TECHNICAL NOTE

Job Name: Bicester Gateway Phase 1b Residential
Job No: 46463
Note No: 006
Date: 30 April 2020
Prepared By: Francois Chate
Subject: Response to OCC comments 23rd March 2020

This Technical Note (TN) provides our response to comments raised by Oxfordshire County Council (OCC) on the transport and highway material submitted in support of the Bicester Gateway Phase 1b planning application.

Figure 12: Regulating Plan.

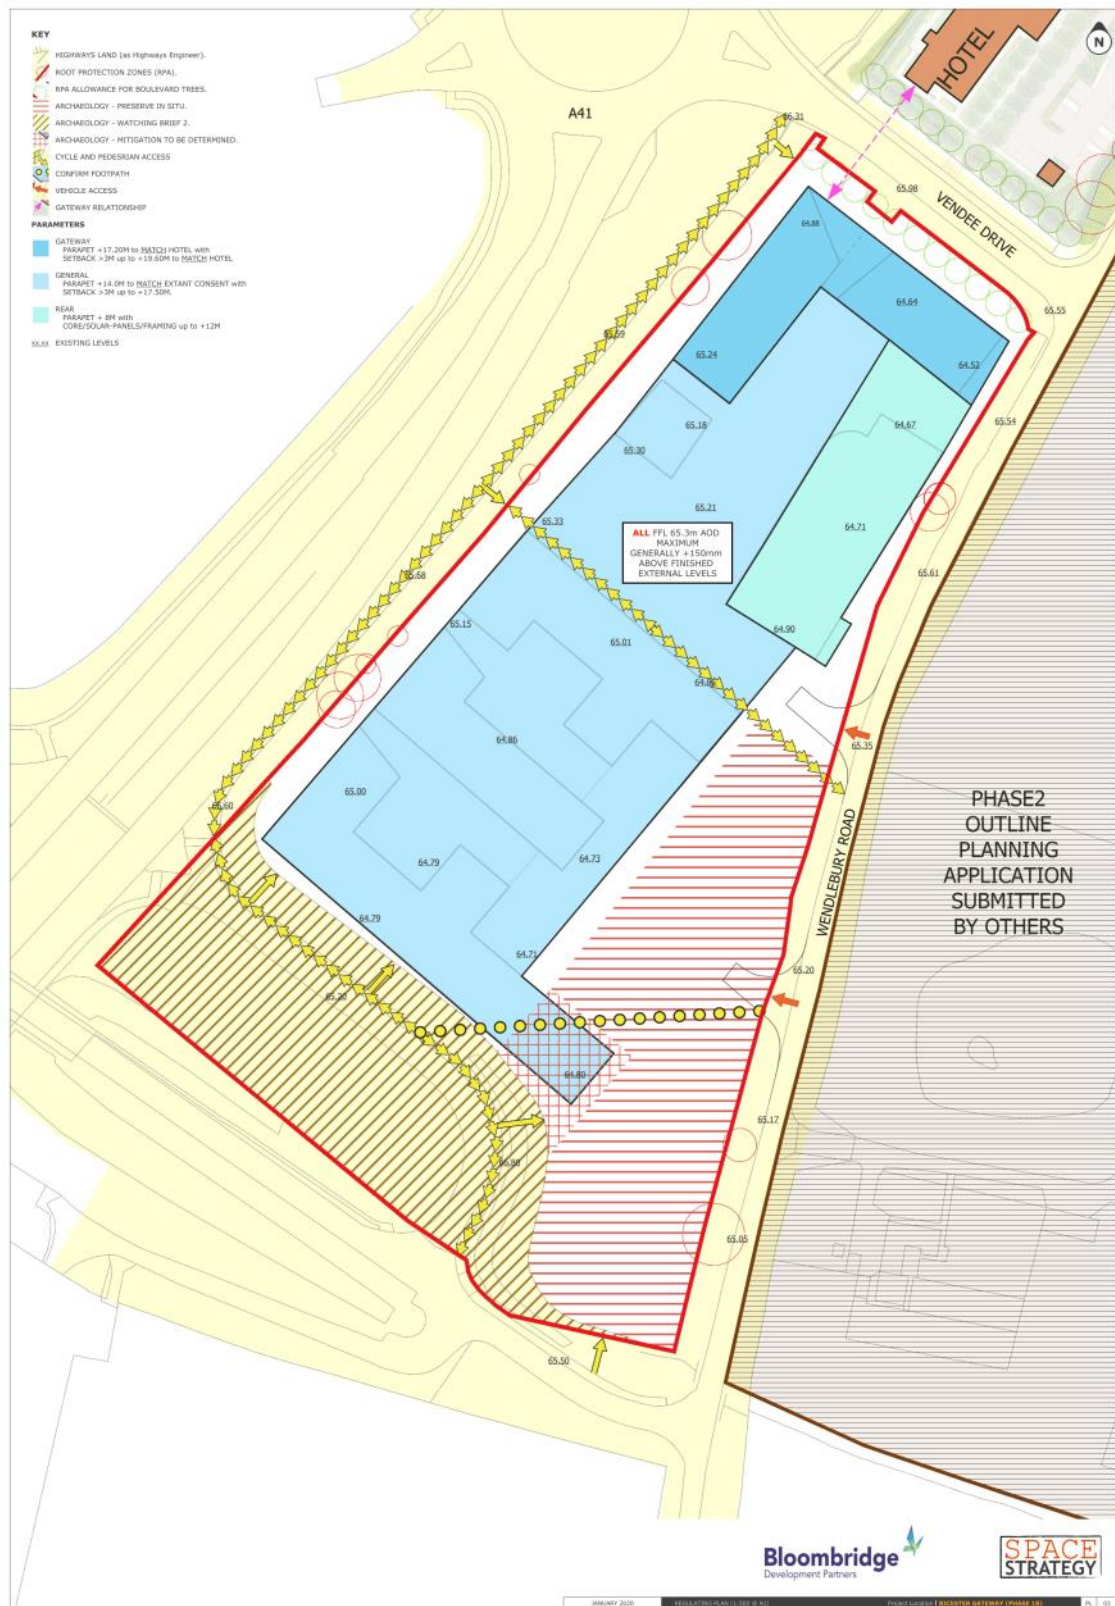
- 2.24. OCC then indicate that provision should be made as part of the Phase 1b proposals to cater for the following:
- Phase 1b pedestrians and cyclists may wish to access the site from Wendlebury Rd – The strategy clearly points all pedestrian and cycle movements to/from the Phase 1b development to the A41, Wendlebury Rd being used for vehicular access only.

- Phase 1b should plan for future interaction with the proposed employment development on the Phase 2 site – There is no certainty that the Phase 2 development will be delivered. The Phase 2 development is not a commitment and therefore the Phase 1b proposals cannot be determined in reference to the emerging Phase 2 proposals. It is for the Phase 2 development to consider how to integrate with the committed Phase 1 development, a point raised separately by Bloombridge.

- 2.25. The Regulating Plan for Phase 1b (Figure 12 of the Design & Access Statement) shows (in yellow arrows) two possible points of future connections with Phase 2, plus Vendee Drive, for the promoters of Phase 2 to respond to in their own Master Plan and Regulating Plan. This is designed to provide for the optimisation of accessibility, notably to the Park & Ride, but it is for Phase 2 to provide these connections in line with whatever development programme emerges for Phase 2 – because there is nowhere to go to until Phase 2 is developed. Figure 12 is extracted and shown in **Appendix A** to this note.
